**KIRKLEES METROPOLITAN COUNCIL
INVESTMENT & REGENERATION SERVICE**

DELEGATED DECISION TO DETERMINE PLANNING APPLICATIONS

Reference No:	2024/62/93052/W
Site Address:	1-2, Well Hill, Underbank Old Road, Holmfirth, HD9 1EG
Description:	Erection of first floor extension to rear and conservatory to front (within a Conservation Area)
Recommending Officer:	Joanna Rednall

DECISION - REFUSE

PROJECT	HD9 1EG		CLIENT	Sykes	
SHEET	Proposed Elevations		Date	Project number	Scale (@ A3)
			25/05/2024	00107	1 : 100
			Drawn by	DRAWING NUMBER	REV
			GB	A108	
			Checked by		
			GB

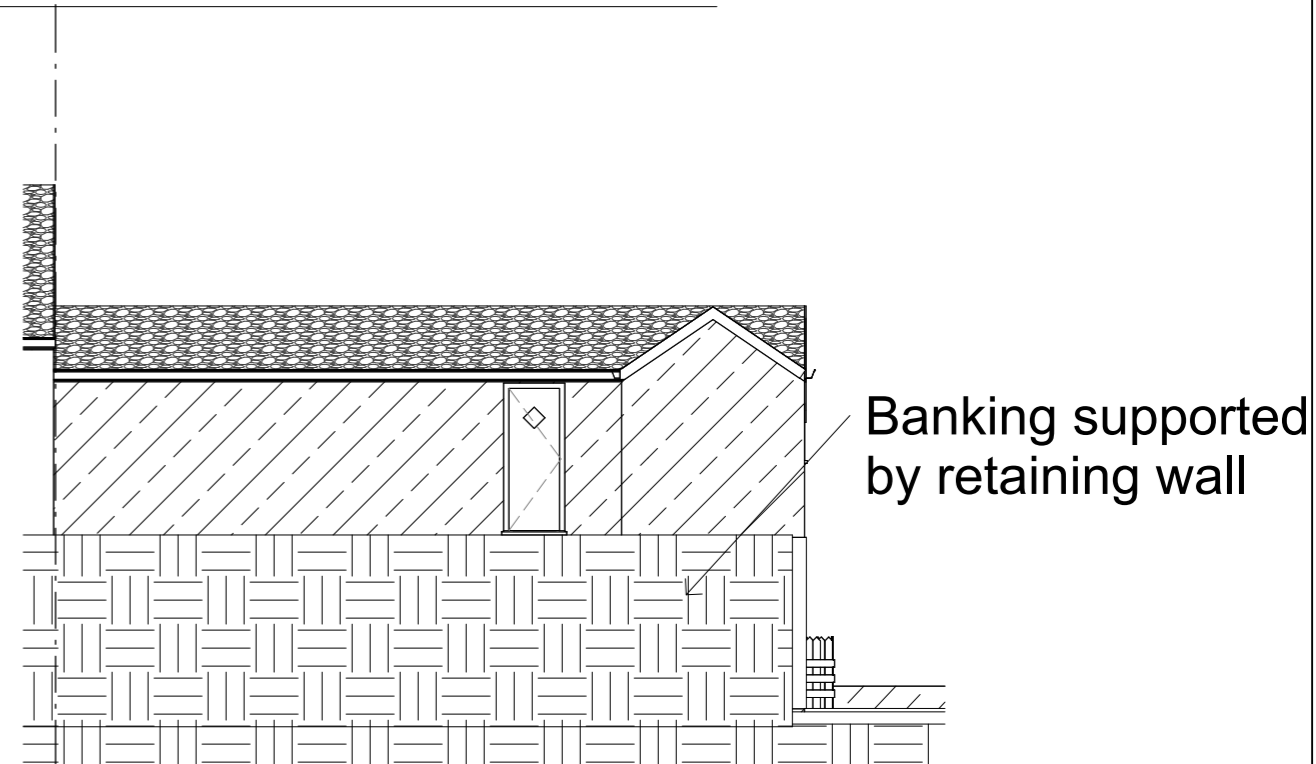
In this context, preservation means not harming the interest of the building itself, or the wider conservation area within which it is set. In this case, the extent of glazing proposed to the extension would not appear to be visually subservient and would alter the character of the property and its traditional form and would not be in keeping with the host and surrounding properties which have strong, defined frontages. The application property occupies a prominent position within the locality and the front extension would appear particularly obtrusive and imposing within the hillside location. The insertion of a conservatory to the front would significantly alter the overall appearance of the traditional weaver's cottage, and it is considered that the front extension would diminish the vernacular character of the dwelling, therefore having a significantly harmful impact on the row of buildings and wider locality.

In addition, turning to the first floor rear extension, Conservation officers have noted it would appear particularly prominent when viewed from public vantage points to the side and rear of the property. It is considered the first floor extension would alter the host's traditional form and the presence of a large extension that is not set down from the host roof and set in from the side elevations would not appear visually subservient to the original house and is not considered to sensitively contribute to the character and appearance of the Conservation Area. This would be contrary to Policy LP35 which seeks to ensure that proposals within Conservation Areas conserve those elements which contribute to significance.

The conservatory is proposed to the front and would extend along the majority of the front elevation of 12 Well Hill. As previously noted, the application property is located in an elevated position within the locality and the proposed development would appear prominent within this hillside location. Although the proposed materials would match those used on the original house, it has been assessed the insertion of a conservatory to the front would cause undue harm to the overall appearance of the traditional weaver's cottage and the use of matching materials would not overcome this considered harm.

The front conservatory extension would form an incongruous feature which is out of character with the host and row of properties. As such, the front extension would be detrimental to the visual amenity of the host dwelling, wider street scene and the character and appearance of the Underbank Conservation Area.

The proposed first floor extension would not increase the footprint of the dwelling, however it would create additional bulk and massing to the rear of the property. The proposed materials would match those used on the host property, and the pitched roof would also match the design of the original house. However, it has been assessed the development would have a harmful visual impact on the setting of the Conservation Area. Although the rear extension is relatively small in scale, it would be located in a prominent location within the street that is visible from public vantage points surrounding the property. It is considered that the cumulatively harmful impact of the front conservatory extension and rear first floor extension would not appear subservient in relation to the host property, and is considered to be out of character with the Conservation Area.

In conclusion, the proposed front conservatory extension and first-floor rear extension, due to their scale, design and appearance, would not appear subordinate to the host property. The introduction of modern features would undermine the traditional character of the dwelling. This would result in a detrimentally harmful impact on the visual amenities of the host dwelling, the local character of the street scene and appearance of the Underbank Conservation Area. To permit such development would be contrary to Key Design Principles 1 and 2 of the SPD, Policies LP24 and LP35 of the Kirklees Local Plan, Policies 1 and 2 of the HVNDP and Chapters 12 and 16 of the NPPF.
